**CITY OF ALBUQUERQUE  
PLANNING DEPARTMENT  
July 9, 2008  
DRB Comments**

**PROJECT # 1007149**

**APPLICATION # 08-70281**

**RE: Tract 122-B, MRGCD Map # 31**

SITE PLAN

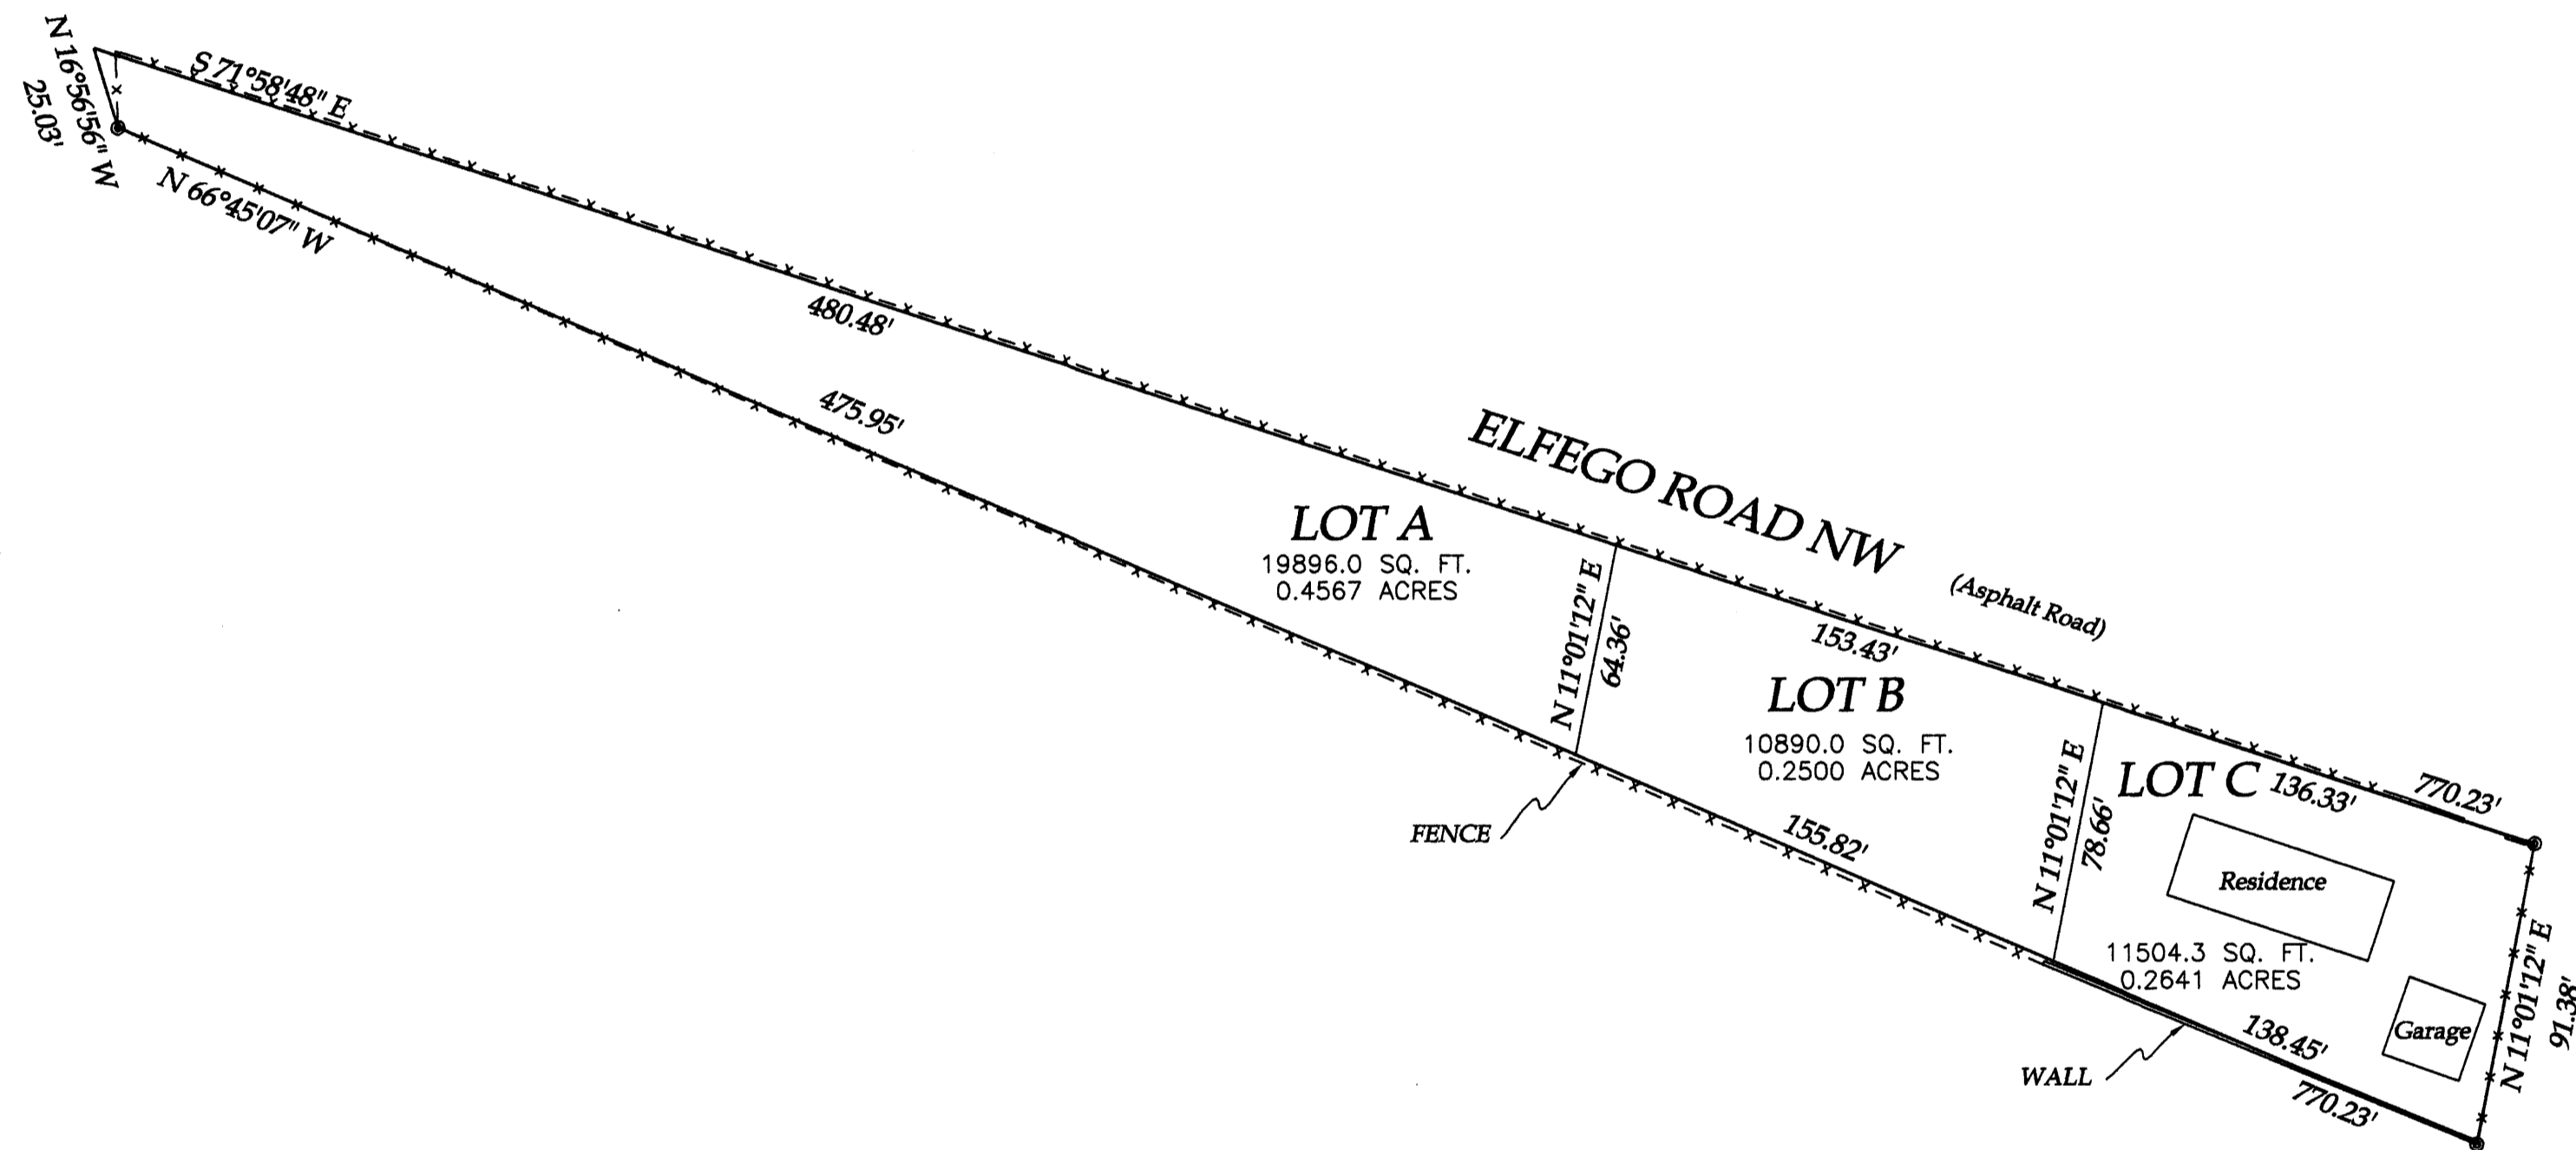
Given the setback requirements of the RA-2 zone (15 feet front, and 25 feet rear), a site plan with a proposed house floor plan is needed to demonstrate the viability for building on proposed Lot A within the required setbacks.

PLAT OF
 LOTS A, B, and C
 LANDS OF YOLANDA SANCHEZ
 (being a replat of Tract 122B, MRGCD Map 31)
 SITUATE WITHIN
 Section 31, Township 11 North, Range 3 East, NMPM
 CITY OF ALBUQUERQUE
 BERNALILLO COUNTY, NEW MEXICO

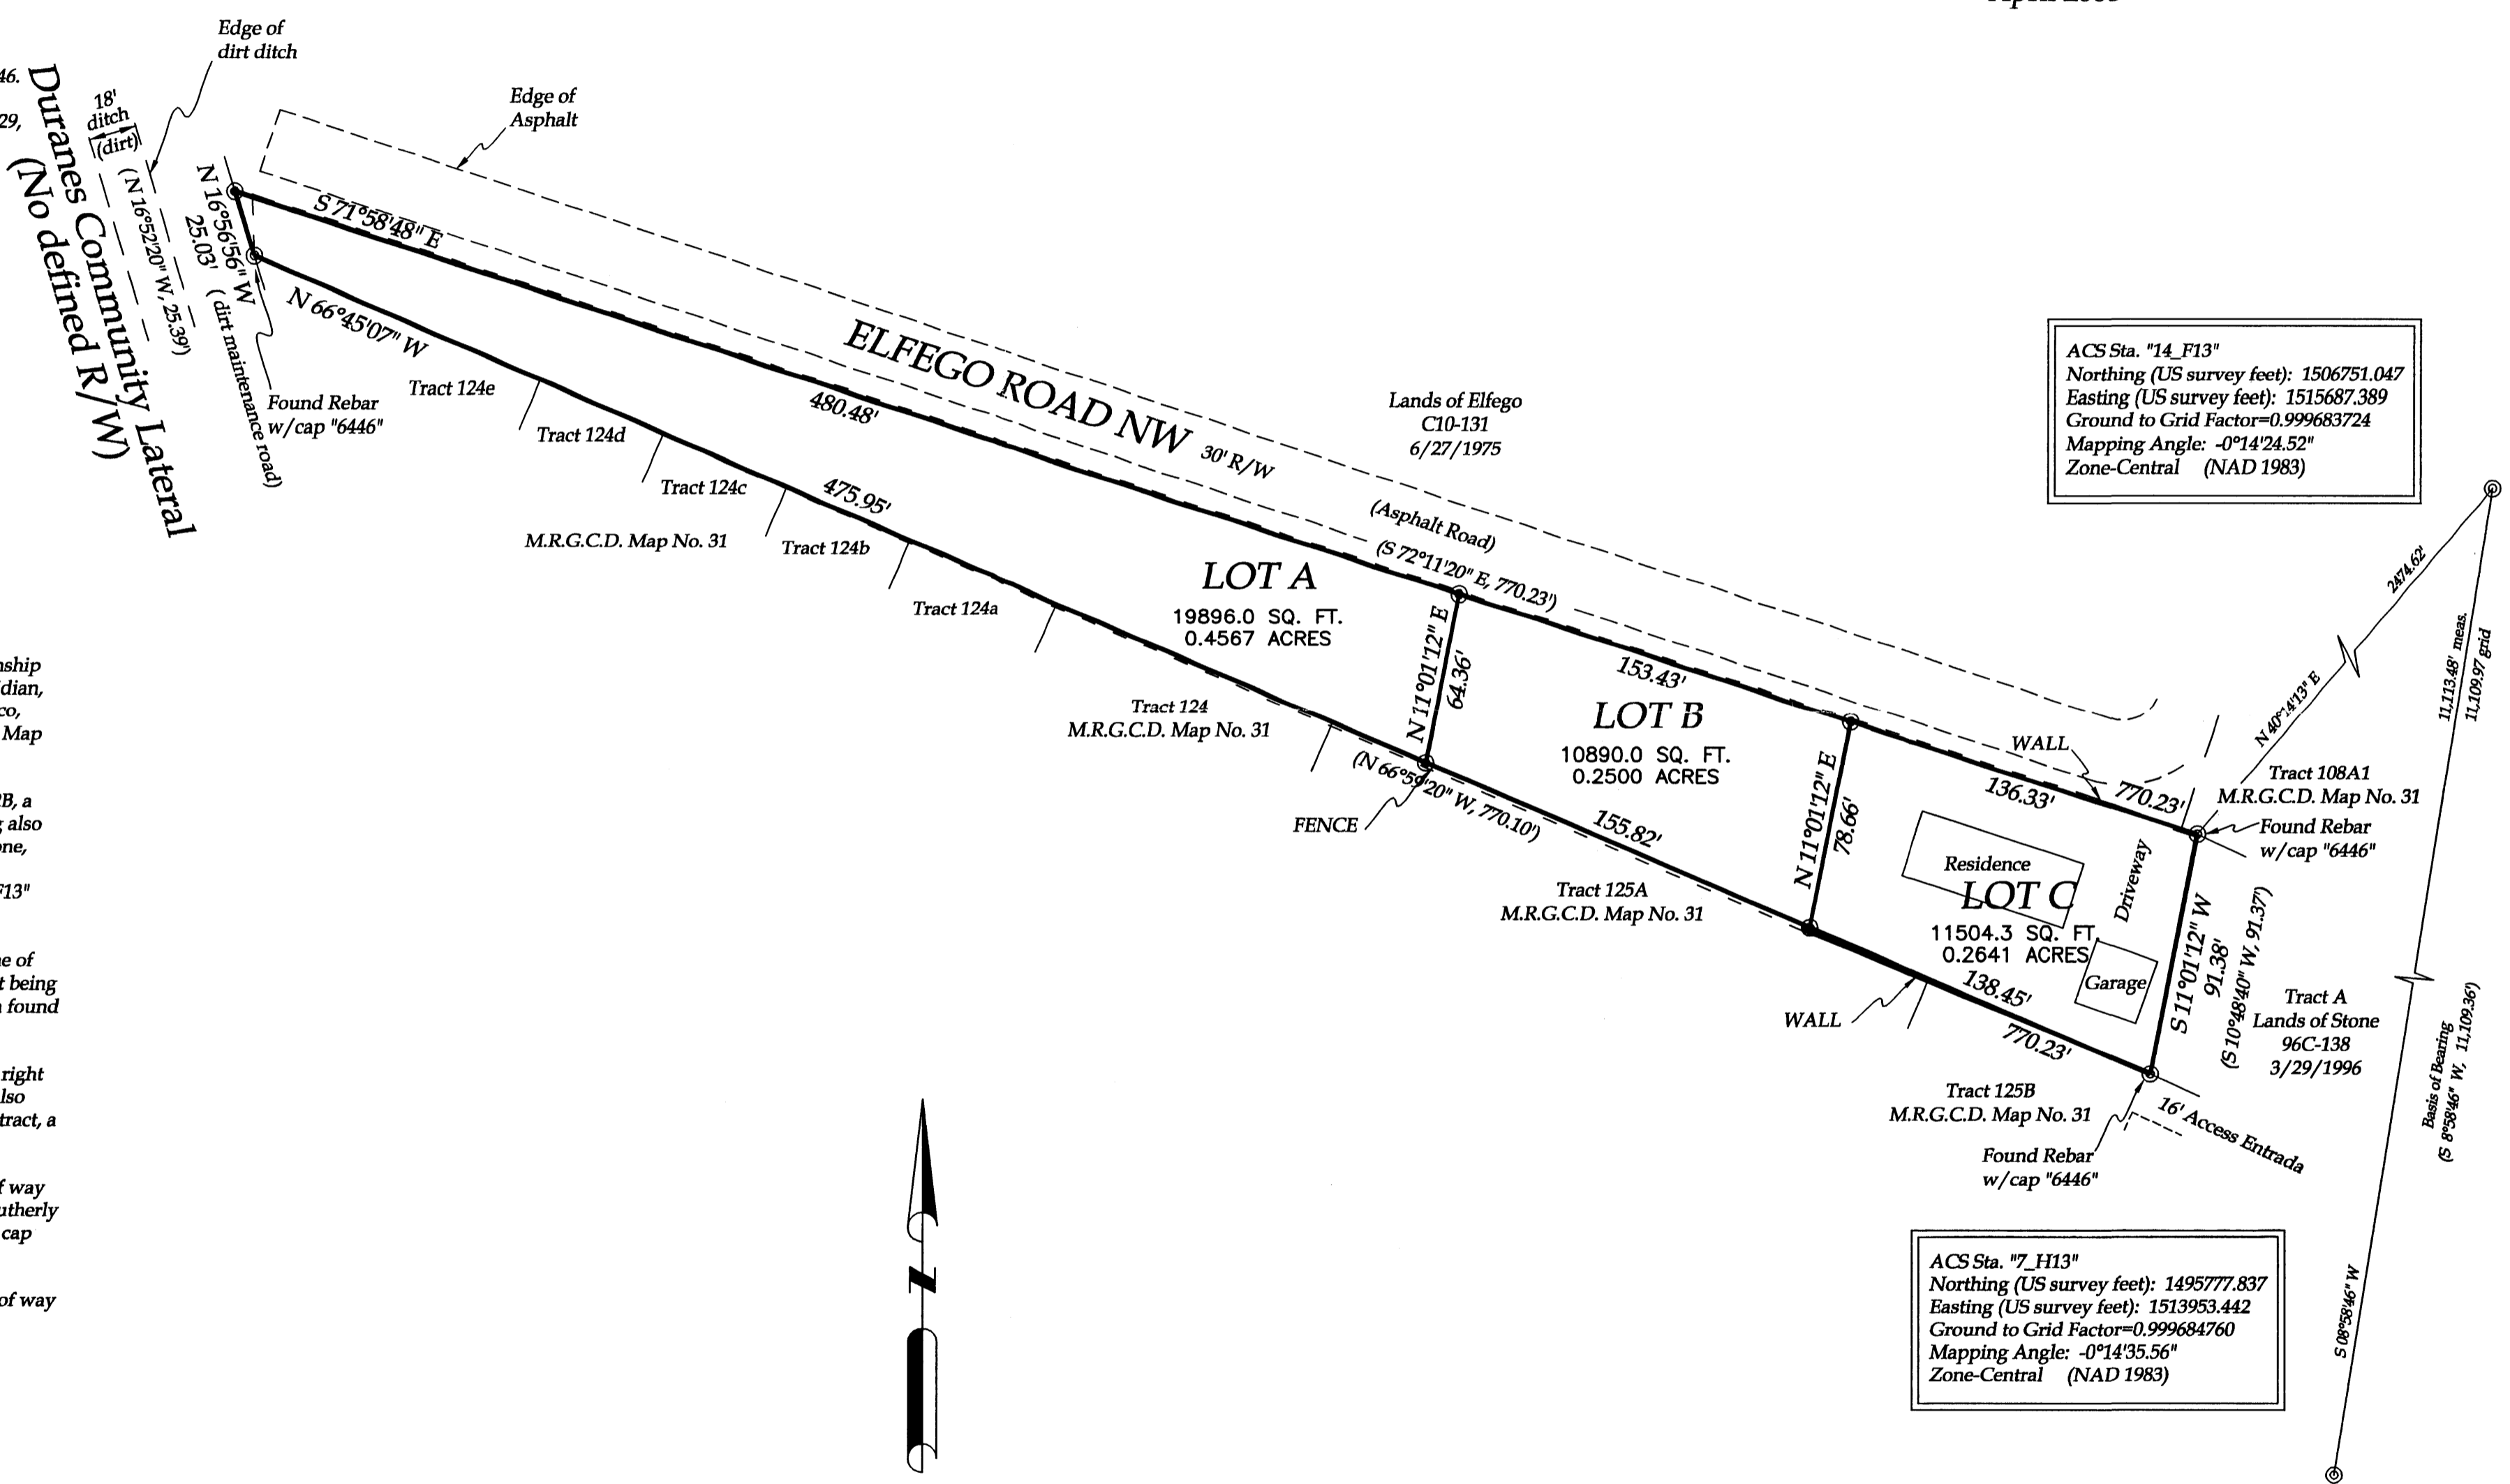
Please remove the "Existing Zoning" note from the plat. A solar collector note per Section 14-14-4-7 of the Subdivision Ordinance is needed - please be specific to this type of request, i.e. use the words "THIS PLAT" and not "REQUESTED FINAL ACTION" in the beginning of the note and delete the words "OR SITE DEVELOPMENT PLAN FOR SUBDIVISION" from the end of the note.
